**From:** Katie Kurek [REDACTED]  
**Sent:** 27 November 2018 14:44  
**To:** Anita Gardner  
**Subject:** RE: Planning Consultation on: A/146/18/PL

**Site Address:**                      Land adjacent to 4 Gladstone Cottages Water Lane Angmering  
BN16 4EL

**Description of Works:** Construction of new semi-detached dwelling extending existing terrace of cottages.

Proposed Site Plan (1:100)

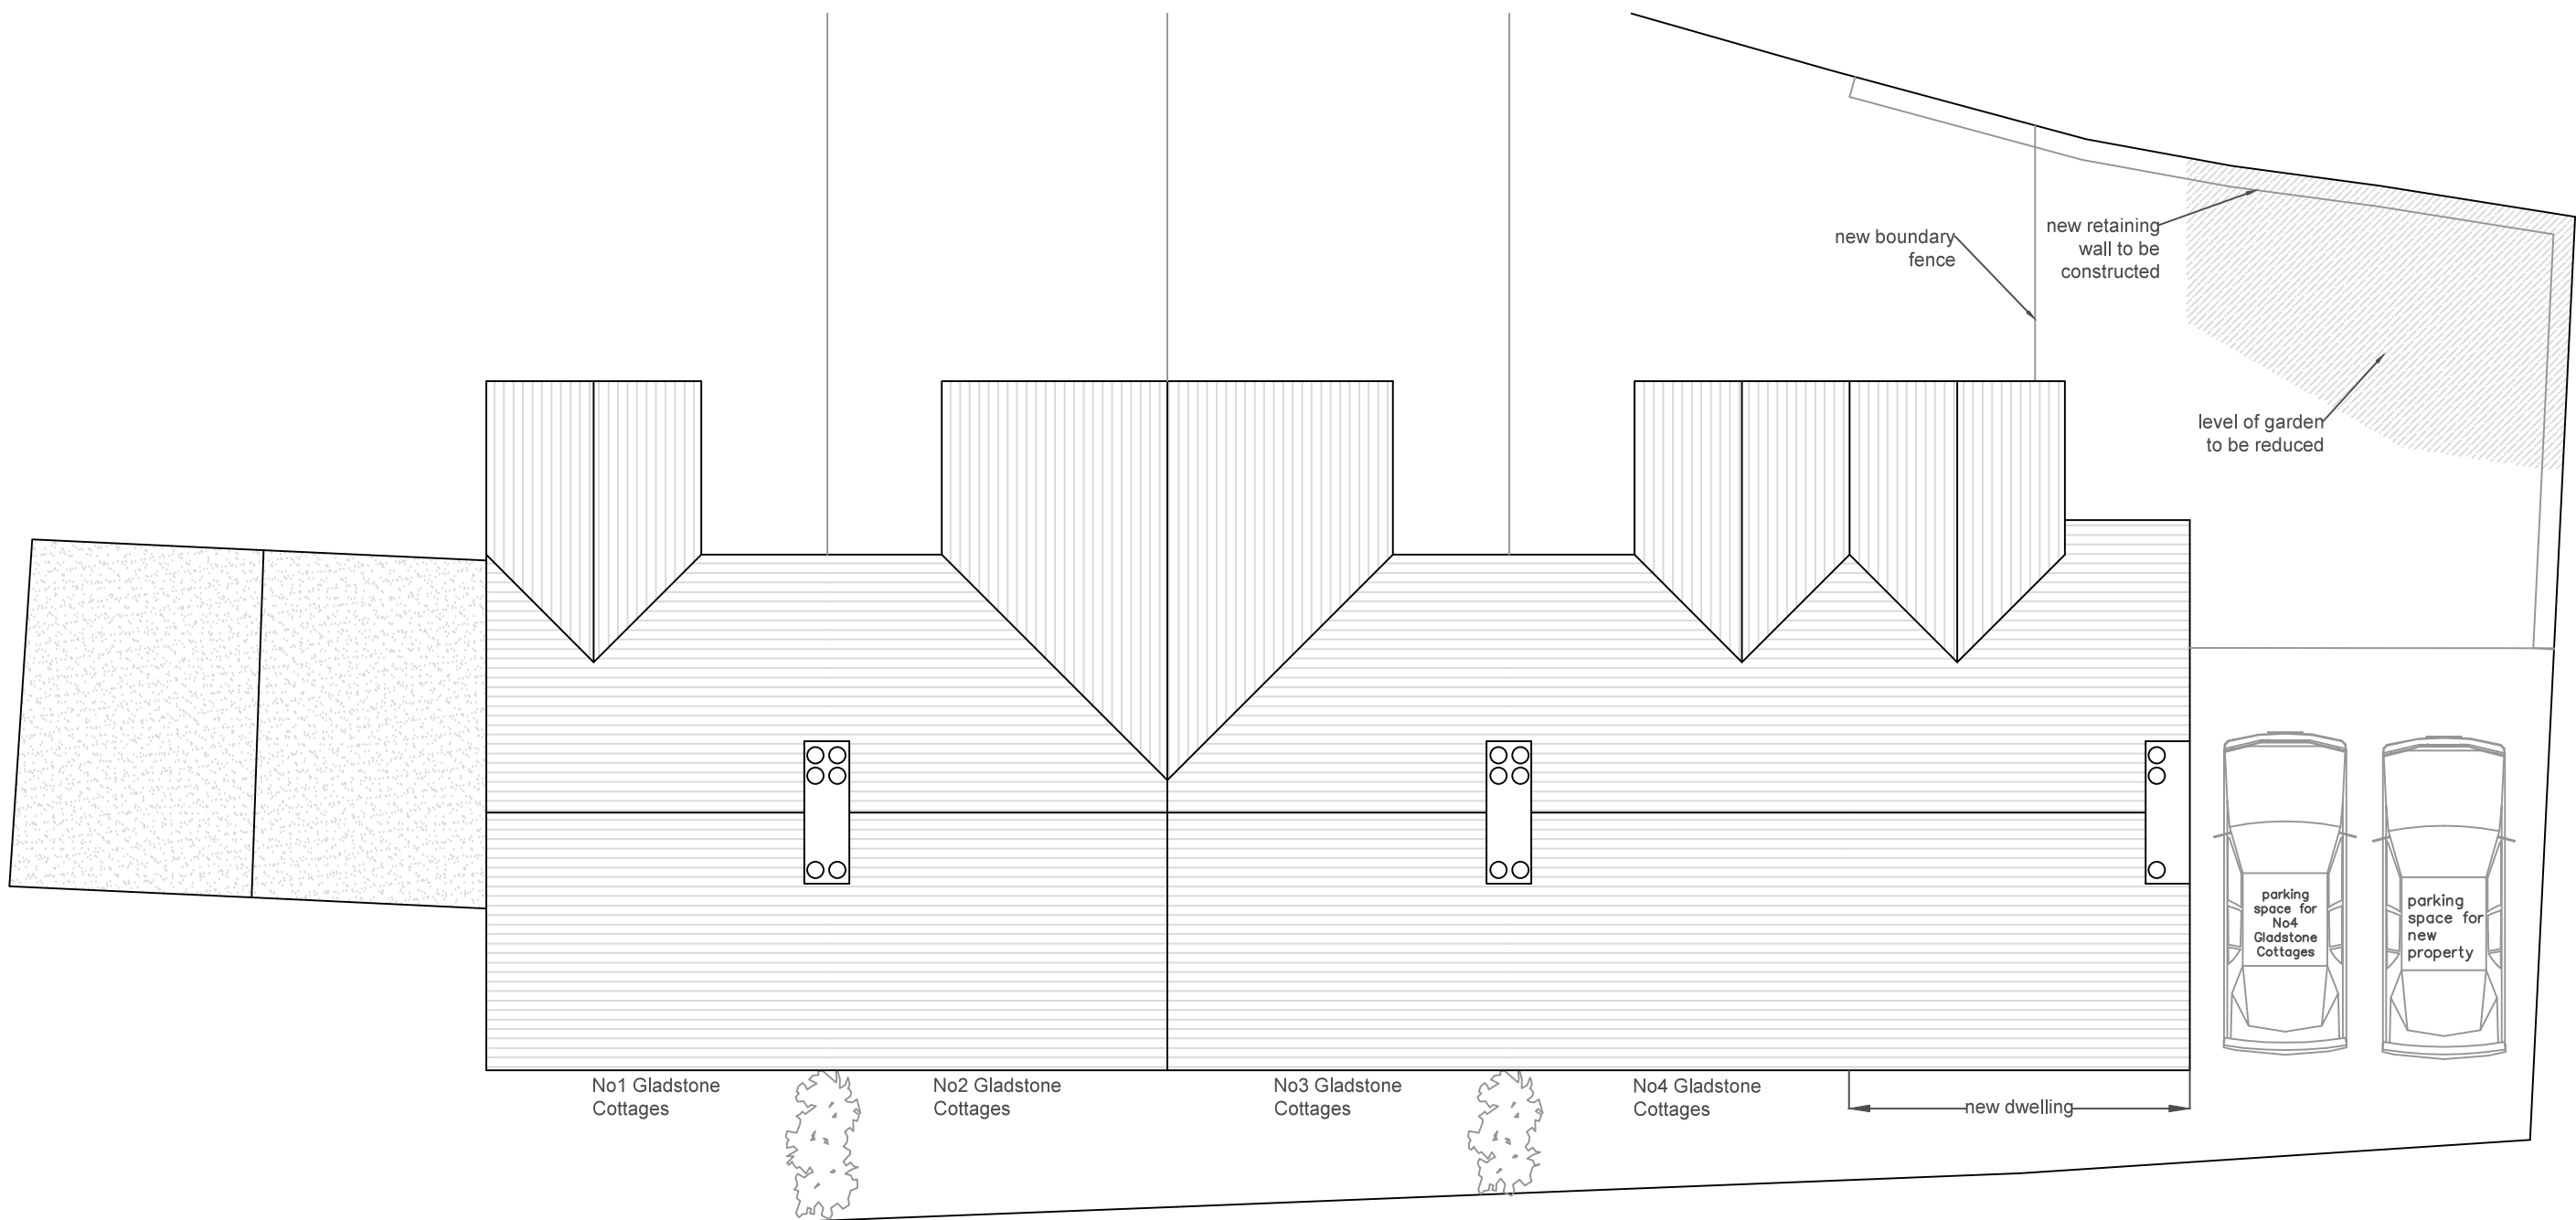
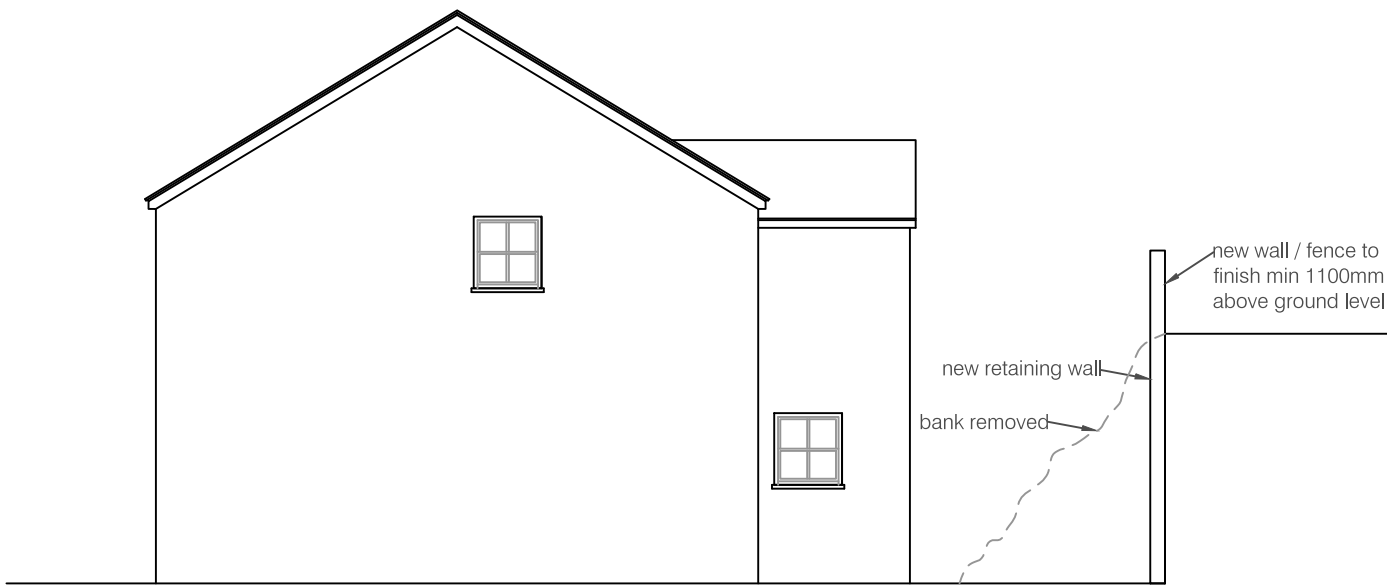
With the removal of the existing off-street parking area and provision of just one space per dwelling yes it is likely that this would not meet parking demand (although without knowing the amount of habitable rooms in the existing dwelling is impossible to predict). Nevertheless, shortfall in parking provision alone is unlikely to be a highway safety reason for resisting the application - providing that visibility is demonstrated as no worse than the existing access point as per my comments.

I visited the site this week. There is an existing access and off road parking space for parking approx. 3 cars . Does this alter your comments regarding parking provision. It does appear that the parking demand would increase and provision would decrease.
